East Anglia ONE North Offshore Windfarm

Appendix 26.1

Traffic and Transport Consultation Responses

Applicant: East Anglia ONE North Limited
Document Reference: 6.3.26.1
SPR Reference: EA1N-DWF-ENV-REP-IBR-000363_001 Rev 01
Pursuant to APFP Regulation: 5(2)(a)

SIZEWELL GAP - ACCESS 1
SCALE - 1:200

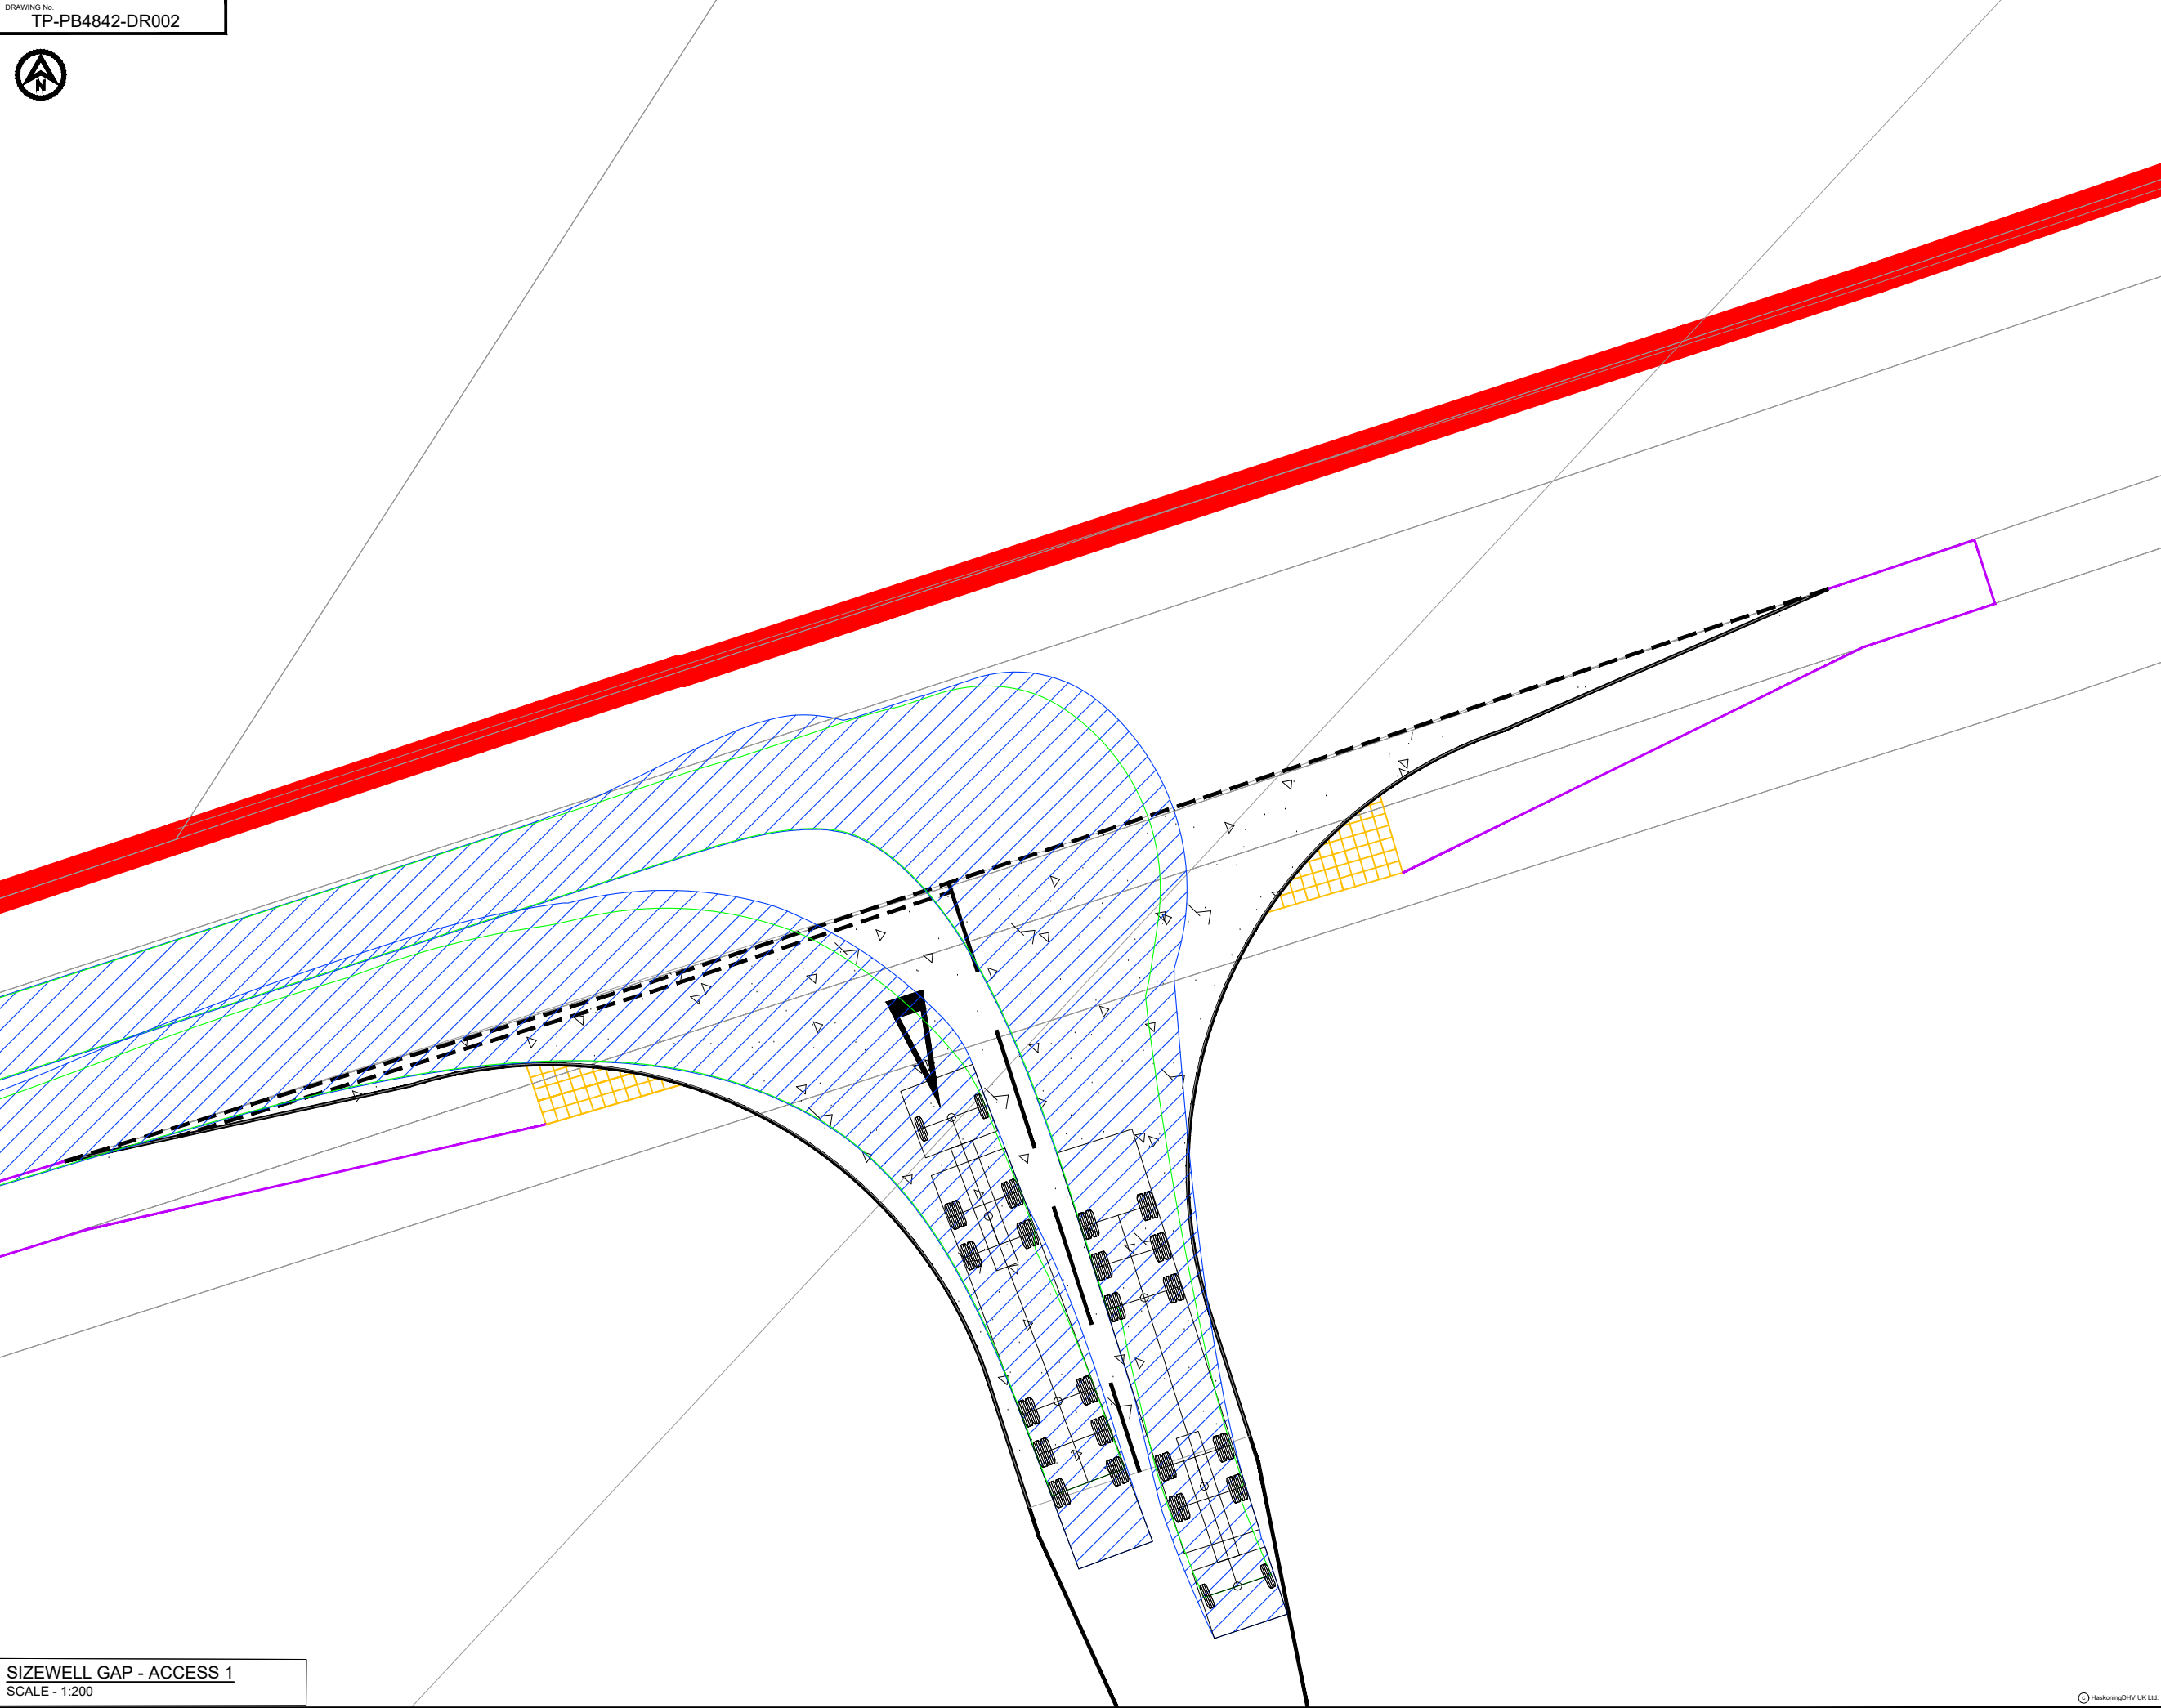
Consultee	Date/ Document	Comment	Response / where addressed in the ES
	Traffic and Transport Meeting	SCC advised that all access proposals should be supported by swept path analysis.	Swept path analysis for each access is provided within Appendix 26.18 .
		The principle of using an pilot vehicle to escort HGVs along the B1353 rather than extensive road widening was discussed. SCC expressed a wish to see further detail regarding how this would operate and the associated delays.	Following consultation feedback the proposed access from the B1353 has been removed by the Applicant.
		Options for how construction vehicles would access either side of the B1353 were presented, (including direct access from the B1353 or access from Sizewell Gap with vehicles crossing the B1353). SCC stated a preference for a signal controlled crossing at the B1353, with HGVs accessing from Sizewell Gap.	Appendix 26.18 provides details of the proposed traffic management proposals for vehicles crossing the B1353.

SIZEWELL GAP - ACCESS 2
SCALE - 1:200

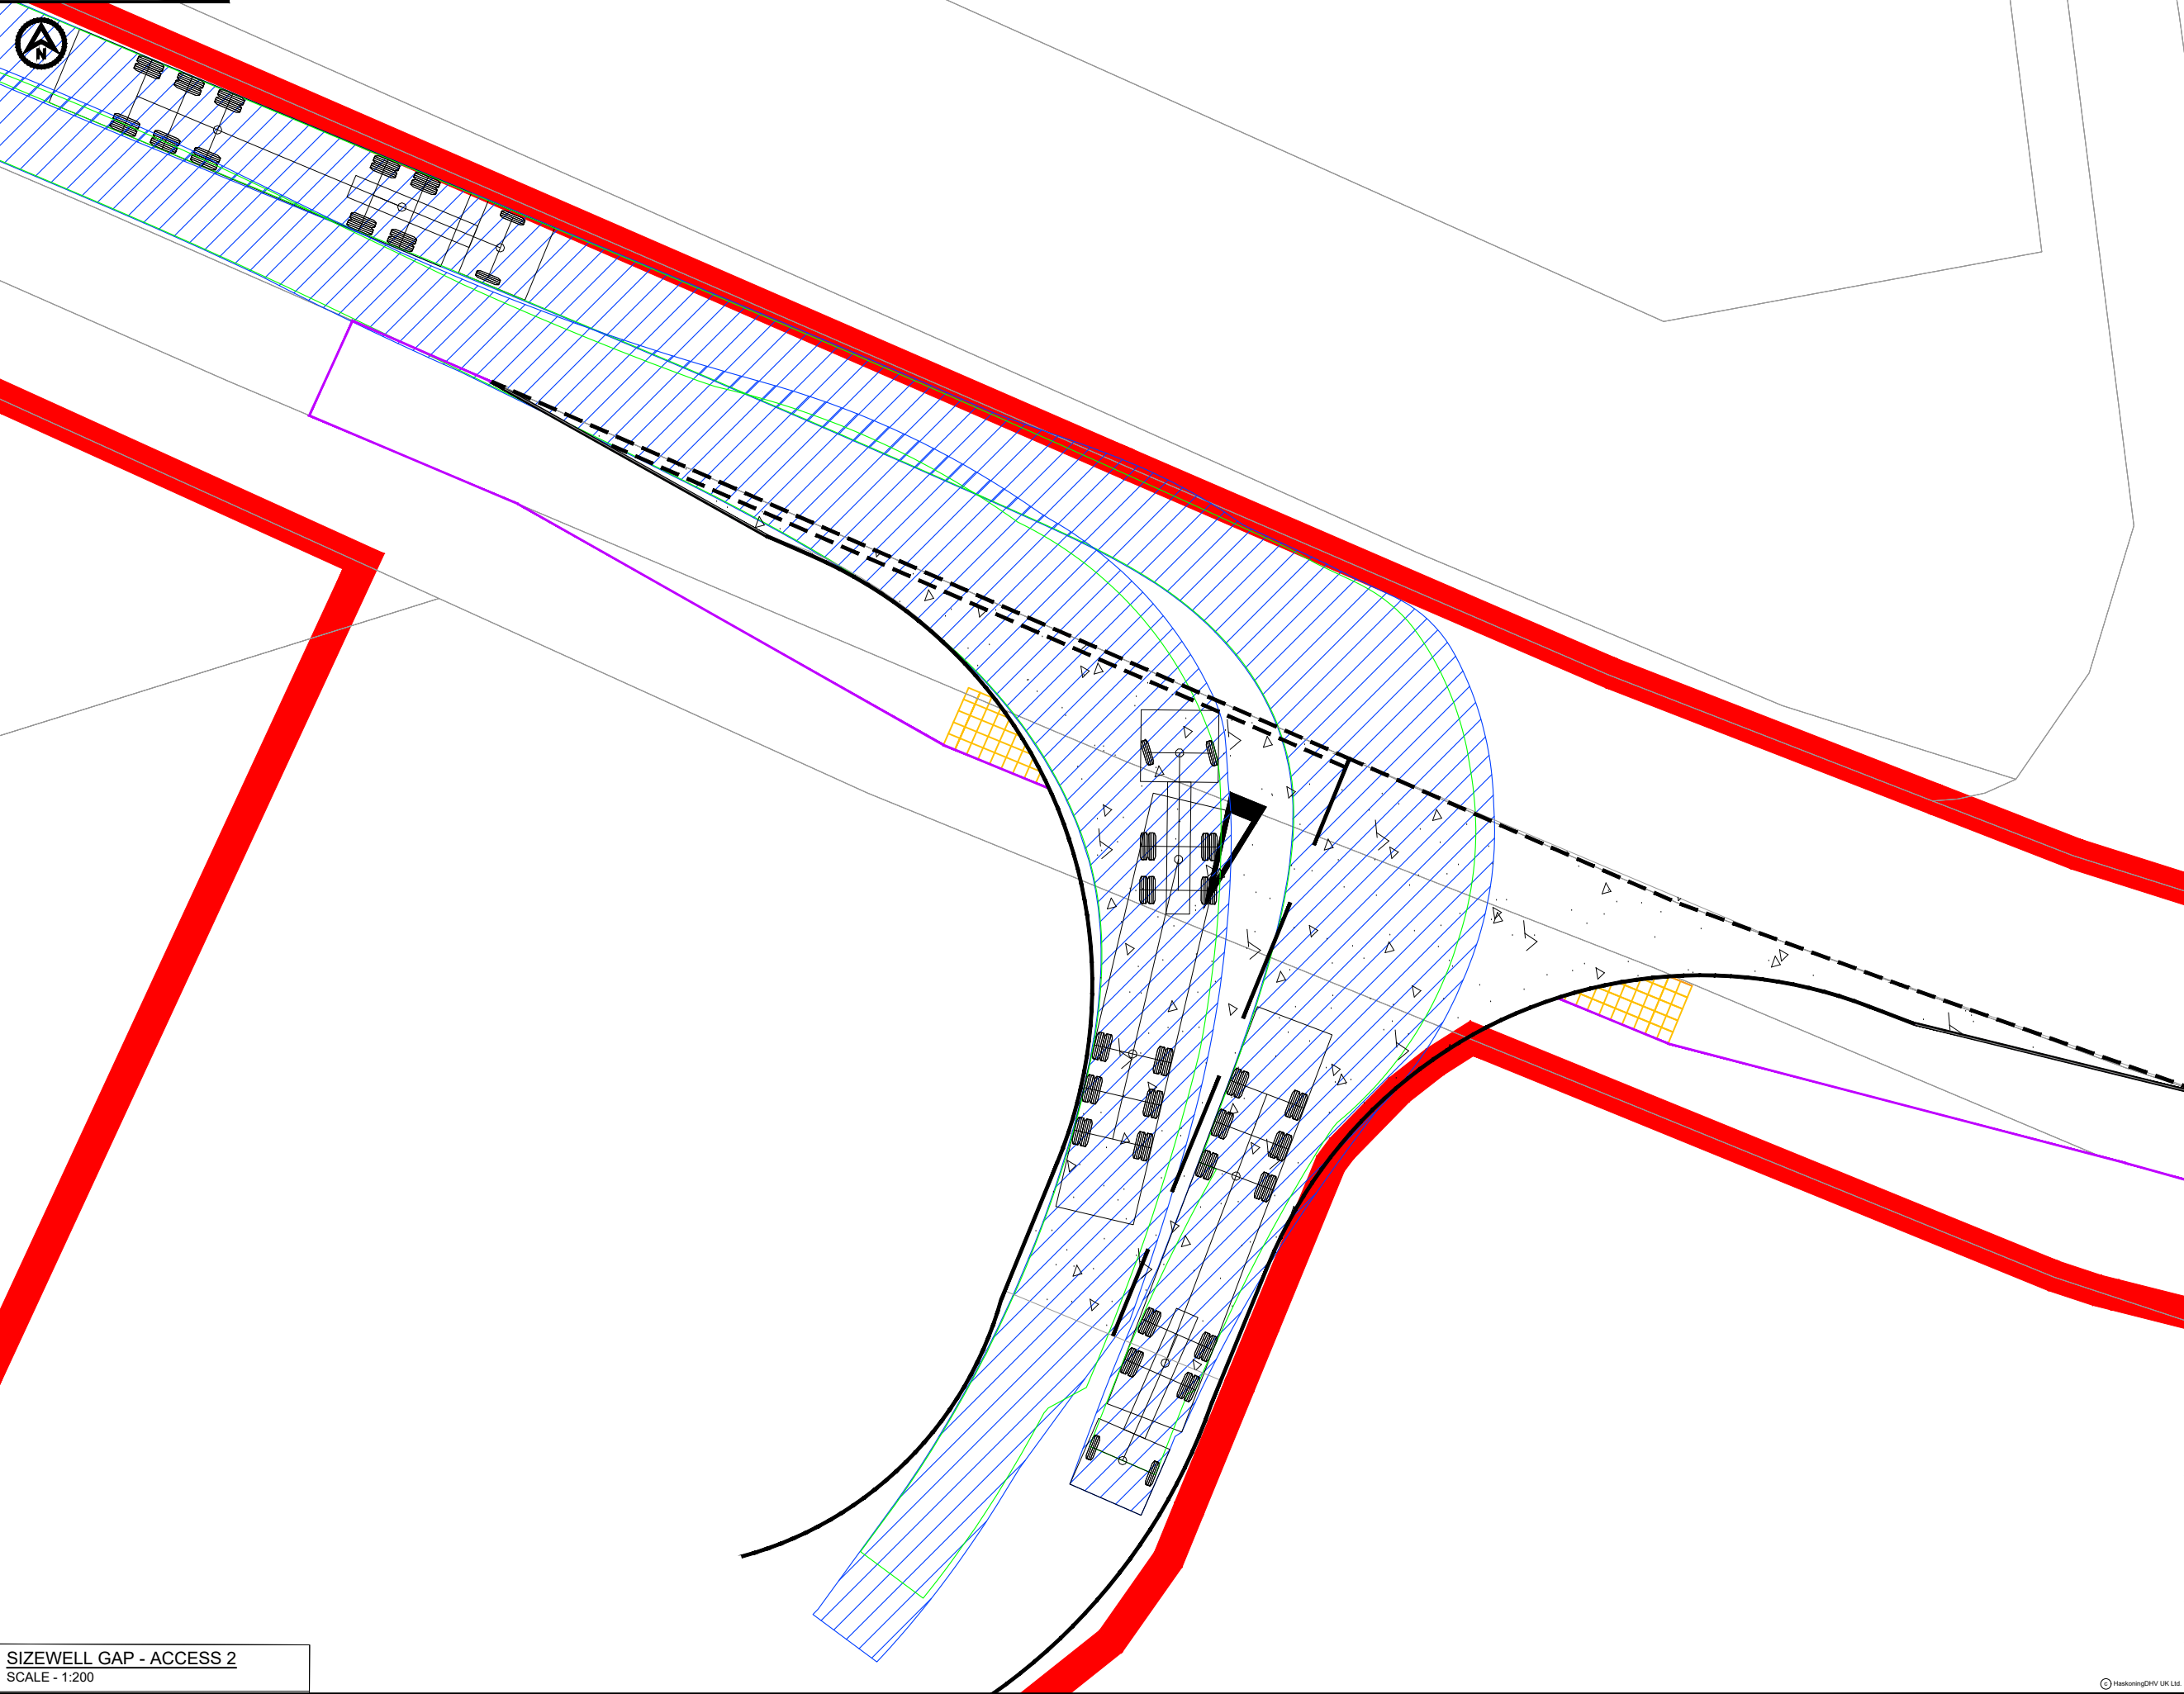
Suffolk County Council and Suffolk Coastal District Council	27.03.2019 Section 42 Consultation Response	For Access 2 off Sizewell Gap Road, due consideration should be given towards the proposals for a cycleway associated with Sizewell C at this location and how the proposed footway could tie-in with this facility.	
Suffolk County Council and Suffolk Coastal District Council	27.03.2019 Section 42 Consultation Response	The PEIR indicates that an outline Construction Traffic Management Plan (CTMP) would be submitted as part of the DCOs and would include details of the measures to be adopted to ensure that traffic demand forecasts are not exceeded, mitigation measures and Travel Plan measures, and the Councils would expect greater clarity on how the proposals will support sustainable transport including through protection of and improvements to the Public Rights of Way network.	An OTP is provided with the DCO submission, secured under the requirements of the draft DCO. The OTP provides details of proposed measures to support sustainable travel.
